9 November, 2021

Your ref: MP10_0108-Mod-1

**RE: SHOALAVEN STARCHES – GAS PIPELINE PROJECT (MP10-0108-MOD-1)
 RESPONSE TO GOVERNMENT SUBMISSIONS**

DWG TITLE: GAS FACILITY, MOD 1. OVERALL SITE PLAN.

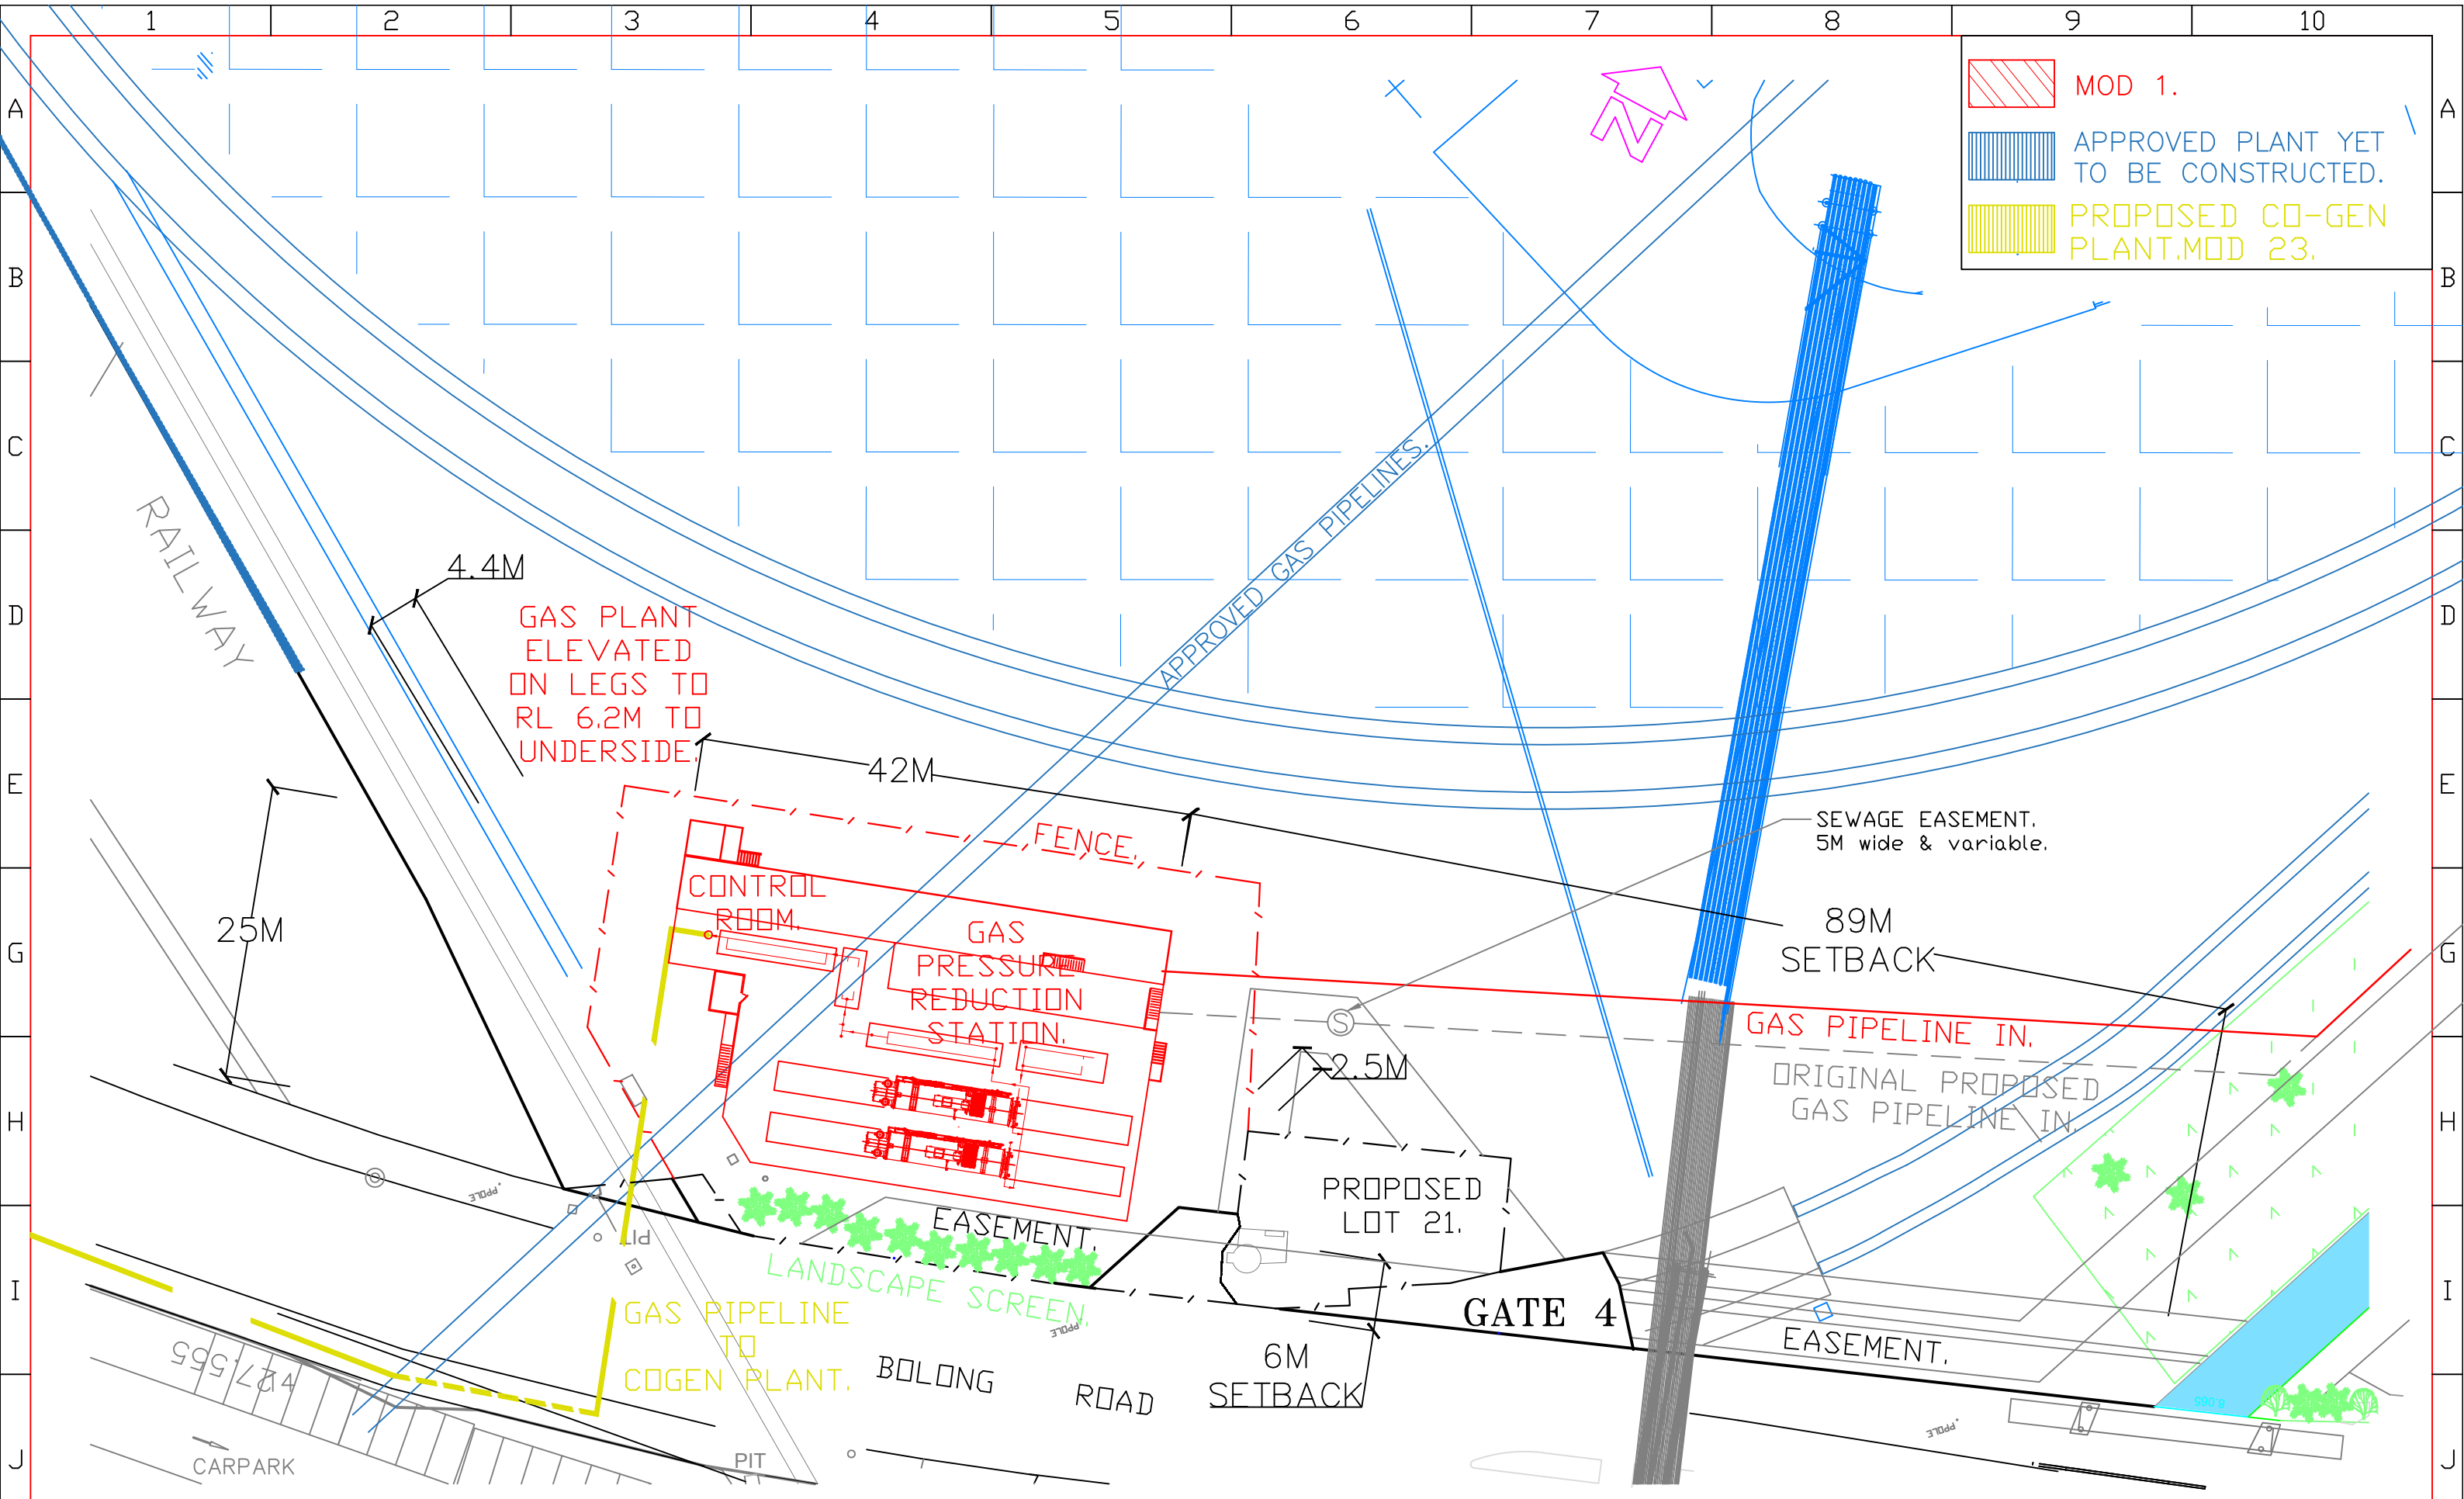
- 1. Council's submission indicates the proposed new location of the Gas Pressure Reduction Station (GPRS), and surrounding fence appears to be located near or over Lot 1 DP 538289 (known as Bolong Road, Bomaderry), which is owned by Shoalhaven City Council for the purpose of a sewer pump station. If the proposed modification is to impact this land, it is unclear whether the consent of Council has been obtained.*

Shoalhaven Starches have reviewed the siting of the GPRS in relation to Lot 1 DP 538289. Firstly, it should be noted that a draft plan of survey that will soon be signed off by Shoalhaven City Council and will then be registered with NSW Land Registry Services that will amend the boundaries of Lot 1 DP 538289. The siting of the GPRS has been reviewed considering this new lot (Proposed Lot 21). Attached to this submission is a revised plan set for this proposal which identifies the boundaries of proposed Lot 21, and which has in effect removed the fencing and landscaping that were previously shown encroaching onto Lot 1 DP 538289. In this regard the area shown to be fenced has been slightly increased to improve access for maintenance purposes around the GPRS.

P.C.	DATE	DWG TITLE	A3
CHKD B.H.	08/12/20	GAS FACILITY, MOD 1. SITE PLAN.	
APPD	DATE	PROJECT No.	REV. P13
	SCALE 1:500	10_0108 MN7297-002

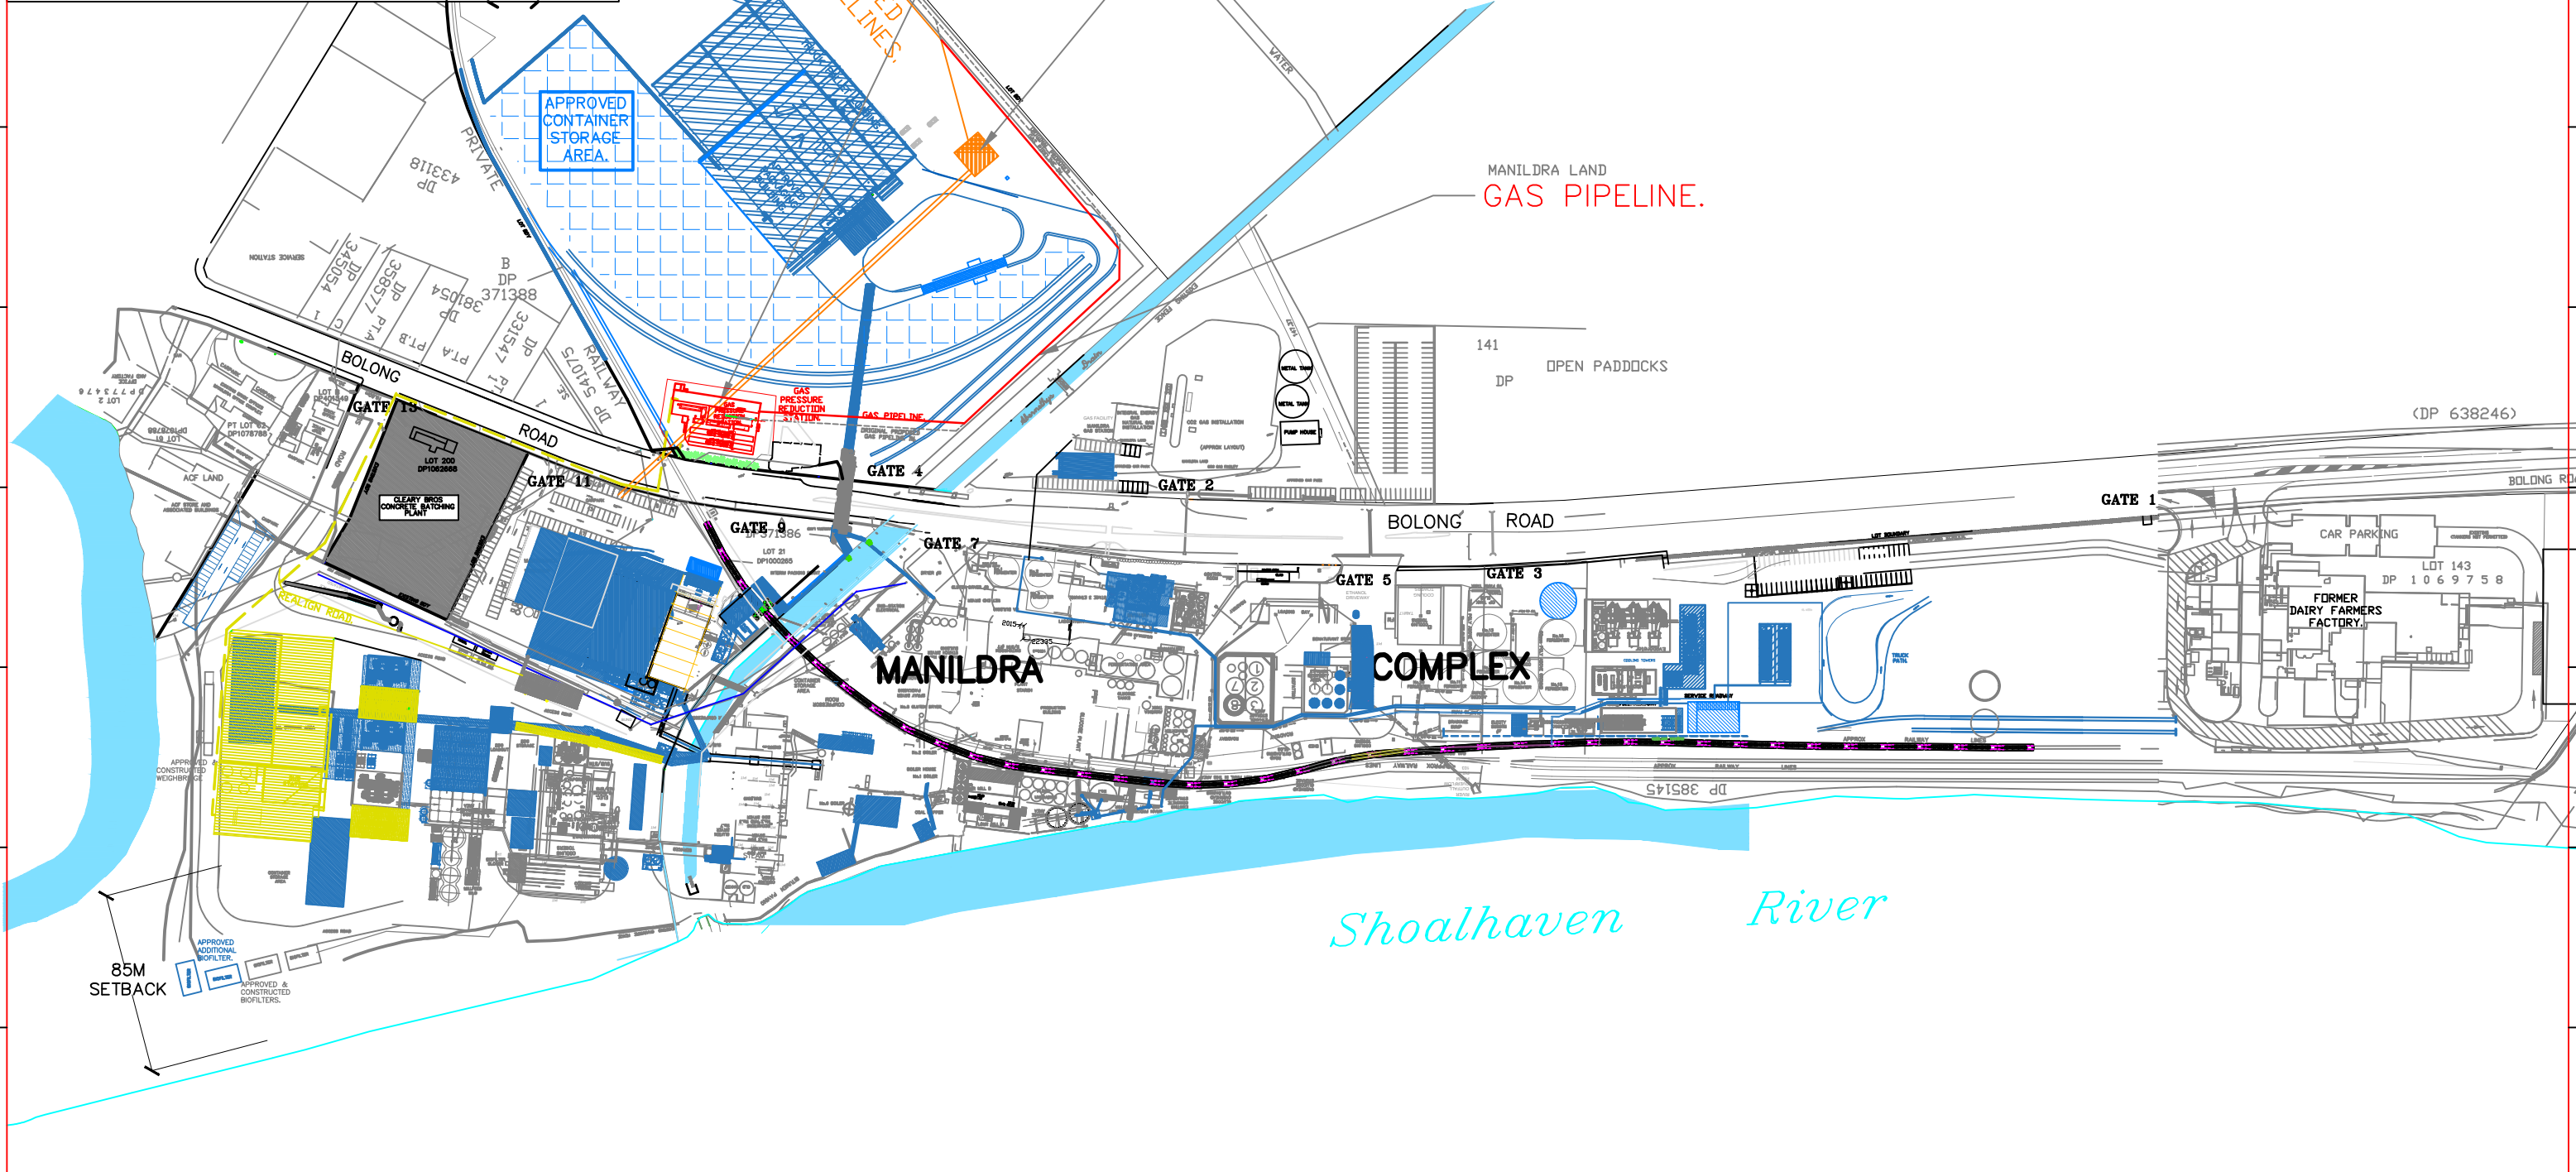
- 2. The property is within the high hazard floodway / flood storage zone with a 2050 scenario Flood Planning Level of 6.2m AHD.*

The attached revised plan set includes the slight raising of the platform upon which the GPRS will sit to ensure the GPRS will sit above the Flood Planning Level identified in Council's submission.
